Please ask for: Ms Iqraa Malik
Email: iqraa.malik@terraquest.co.uk
Telephone: 0121 234 1390
Our Ref: FP/39/25/HH
Your Ref:
Date: 21st March 2025

Application for Planning Permission for Works or Extension to a Dwelling

Development: Single storey rear extension with steps, front canopy, conversion of loft to habitable use with rear dormer and alterations to fenestration. Detached car port and widen driveway entrance with new electric gate and pedestrian access.
Location: 21 Goodwood Avenue Felpham PO22 8EH

Dwg. No. P-003
 Title: Proposed First and Second Floor Plans
 Address: 21 Goodwood Avenue, Felpham, PO22 8EH
 Client: Jonathan and Lauren Penn
 Scale: 1:100@A3
 Stage: PLANNING
 Drawn: PS
 Date: February 2025

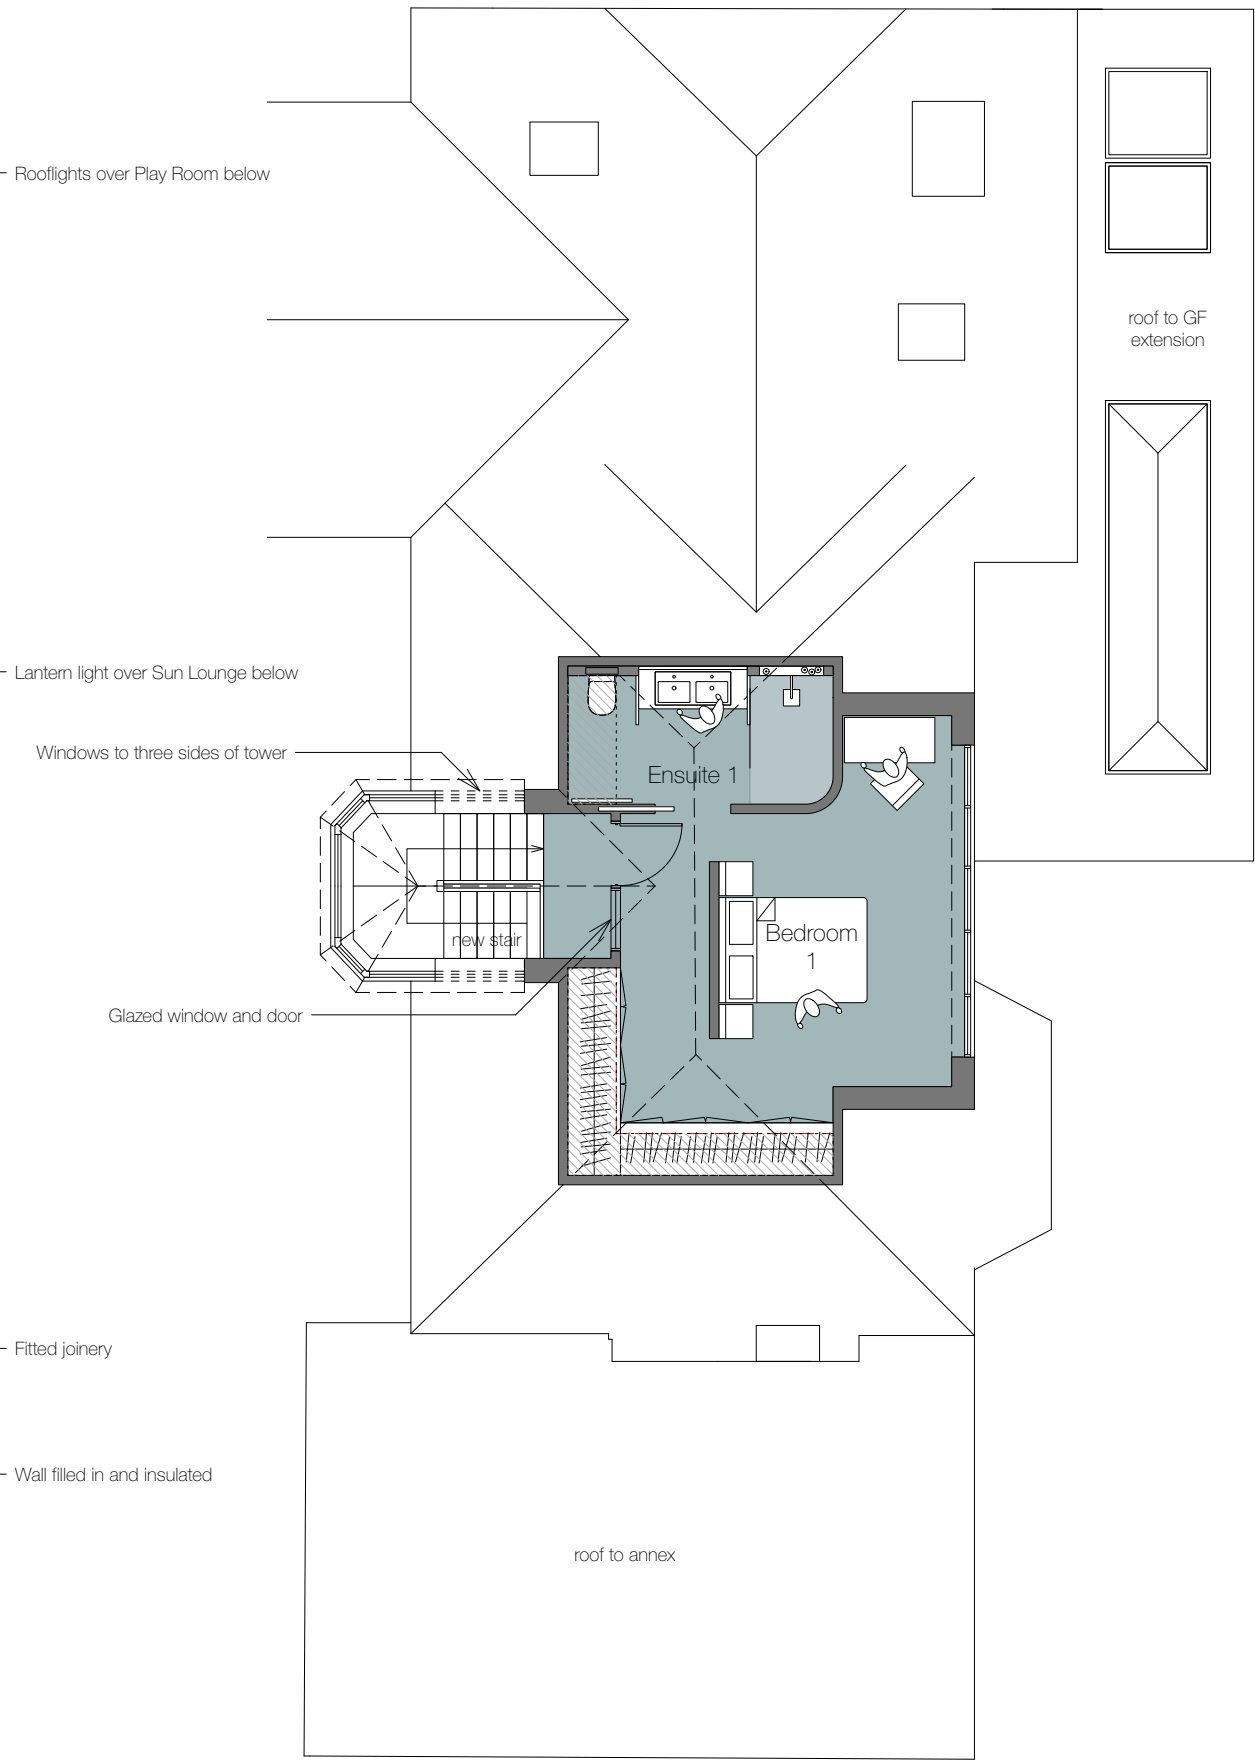
The proposed first floor plan is inconsistent with the proposed north elevation, please review and amend. In addition to this, the proposed east elevation is inconsistent with the proposed ground floor plan.

Dwg. No. P-008
 Title: Proposed Sectional Elevation and Gate Elevations
 Address: 21 Goodwood Avenue, Felpham, PO22 8EH
 Client: Jonathan and Lauren Penn
 Scale: Stated@A3
 Stage: PLANNING
 Drawn: PS
 Date: March 2025

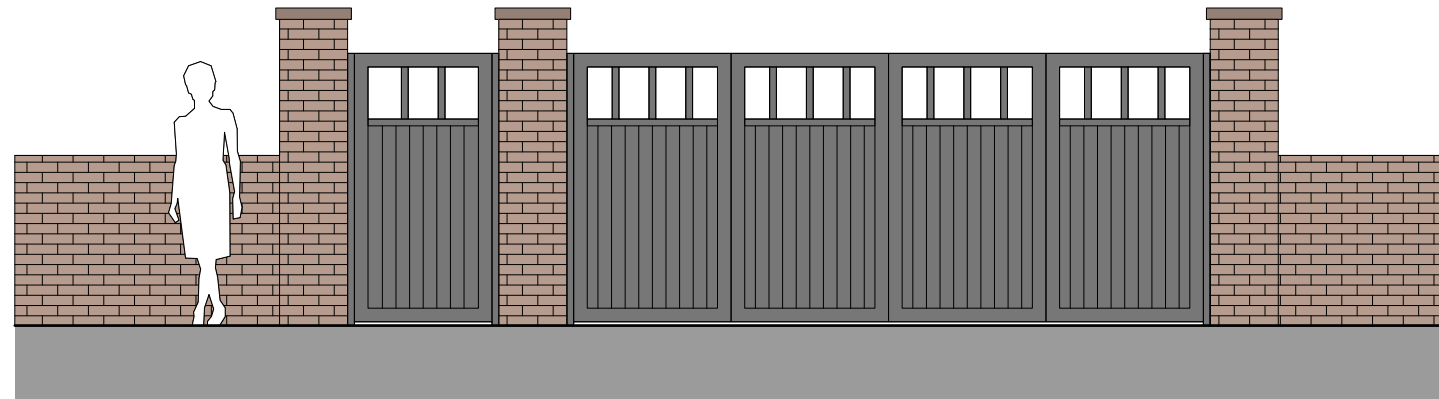
Please submit the proposed north elevation without the carport obstructing the view

Please submit electronic plans in pdf format clearly labelled proposed gate elevations at a scale of 1:50 or 1:100. Further details can be found in the Validation Requirements List.

Dwg. No. E-001B
 Title: Location and Site/Block Plan
 Address: 21 Goodwood Avenue, Felpham, PO22 8EH
 Client: Jonathan and Lauren Penn
 Scale: Stated@A3
 Stage: PLANNING
 Drawn: PS
 Date: January 2025

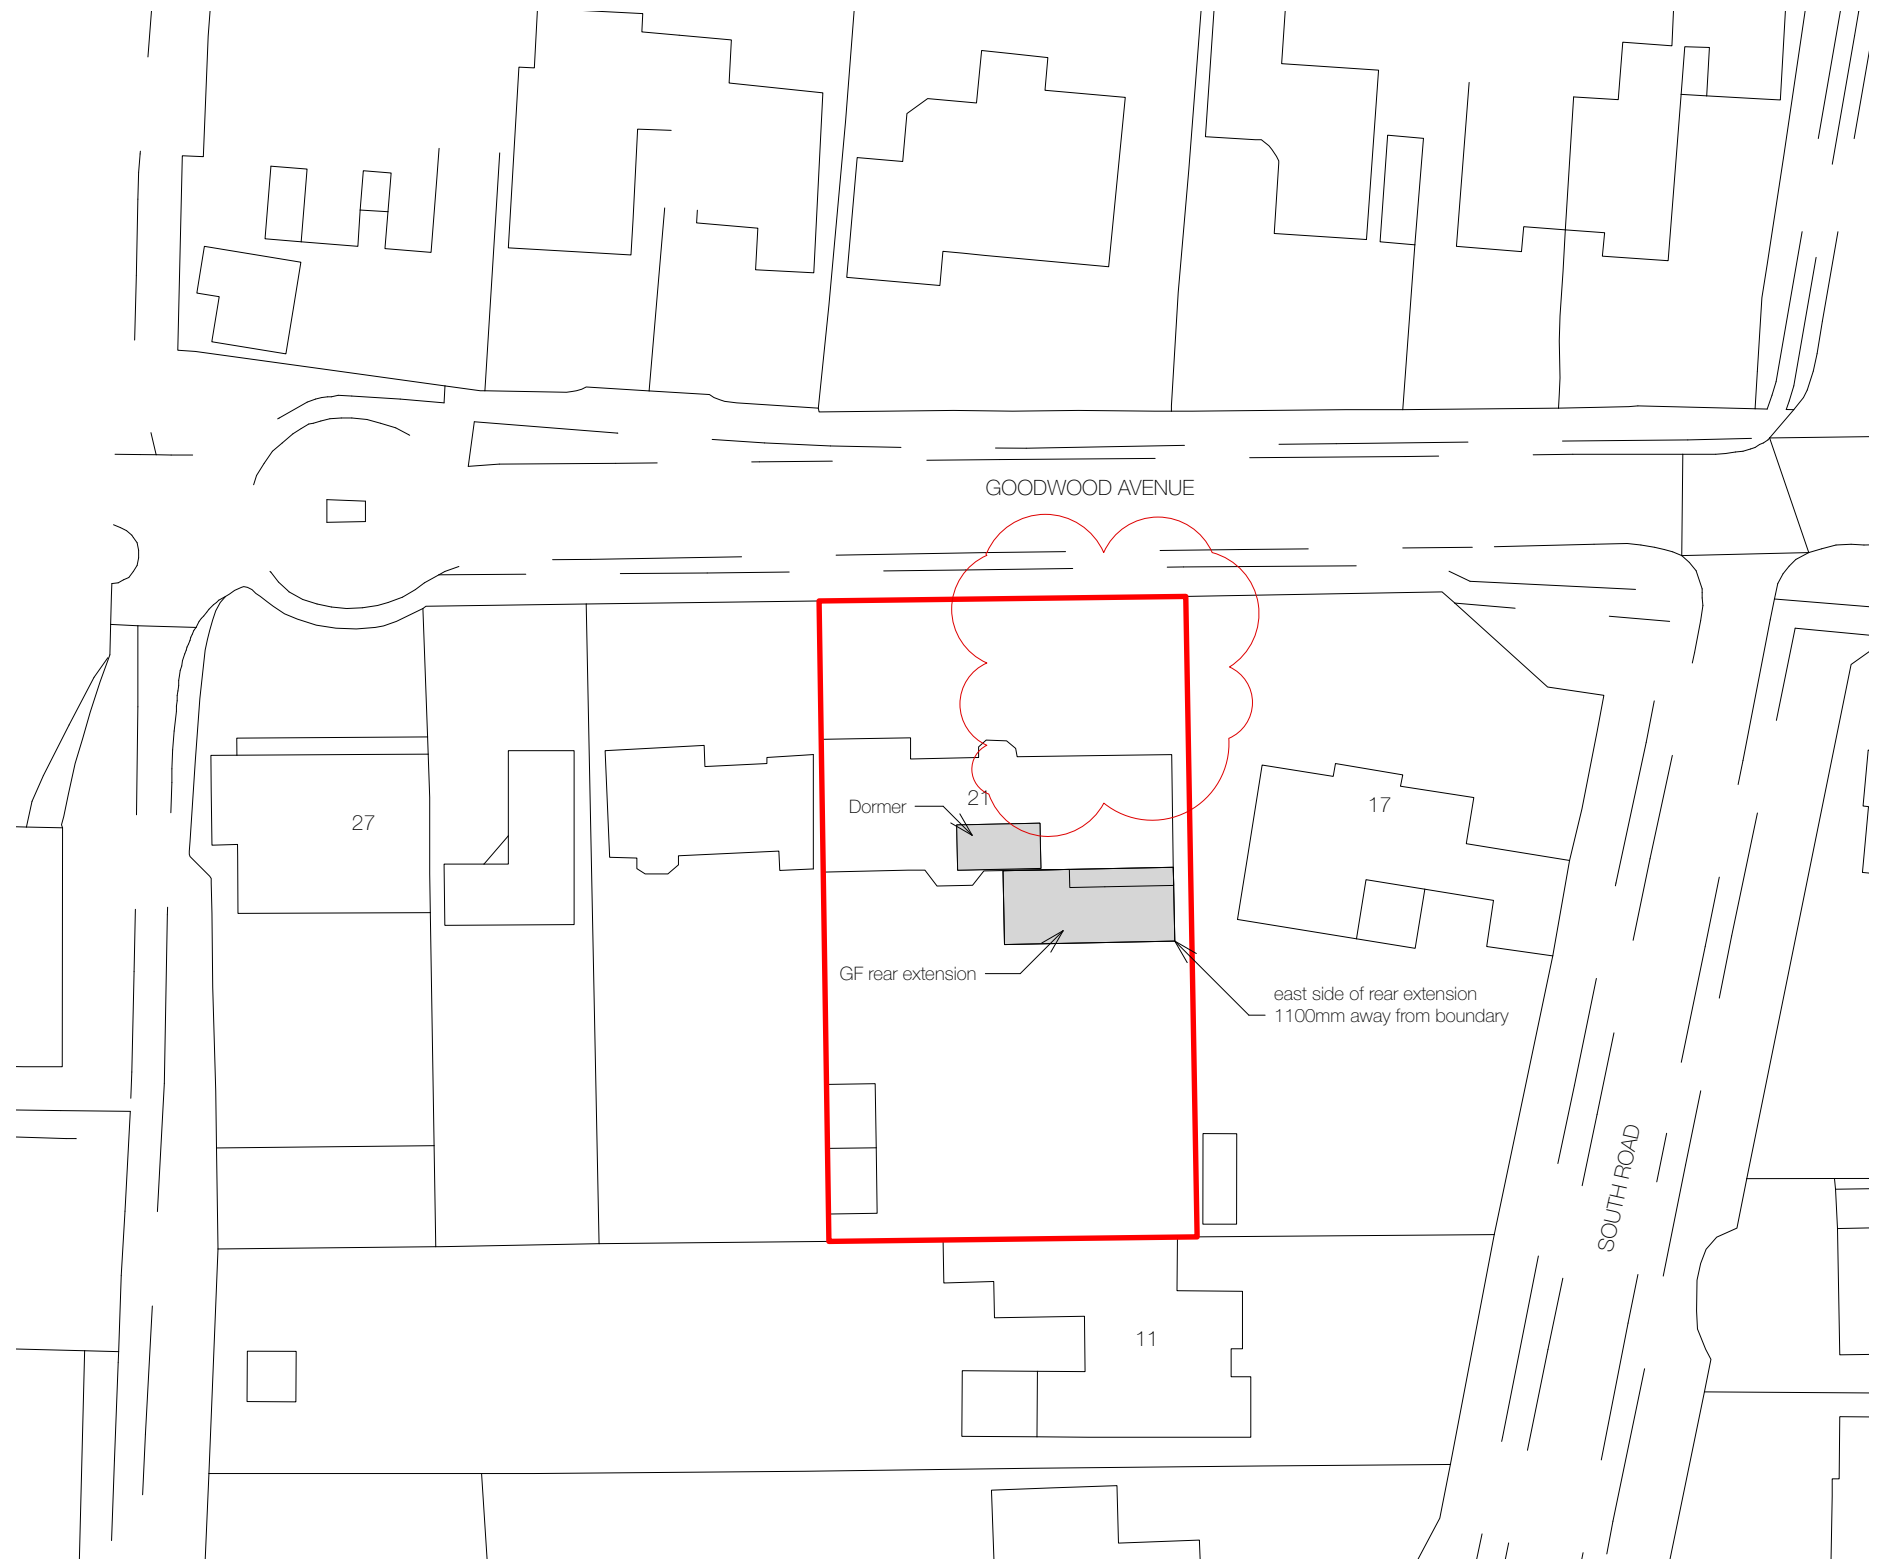
You are required to have dimensions from the proposed extension(s) to all site boundaries. Please amend.
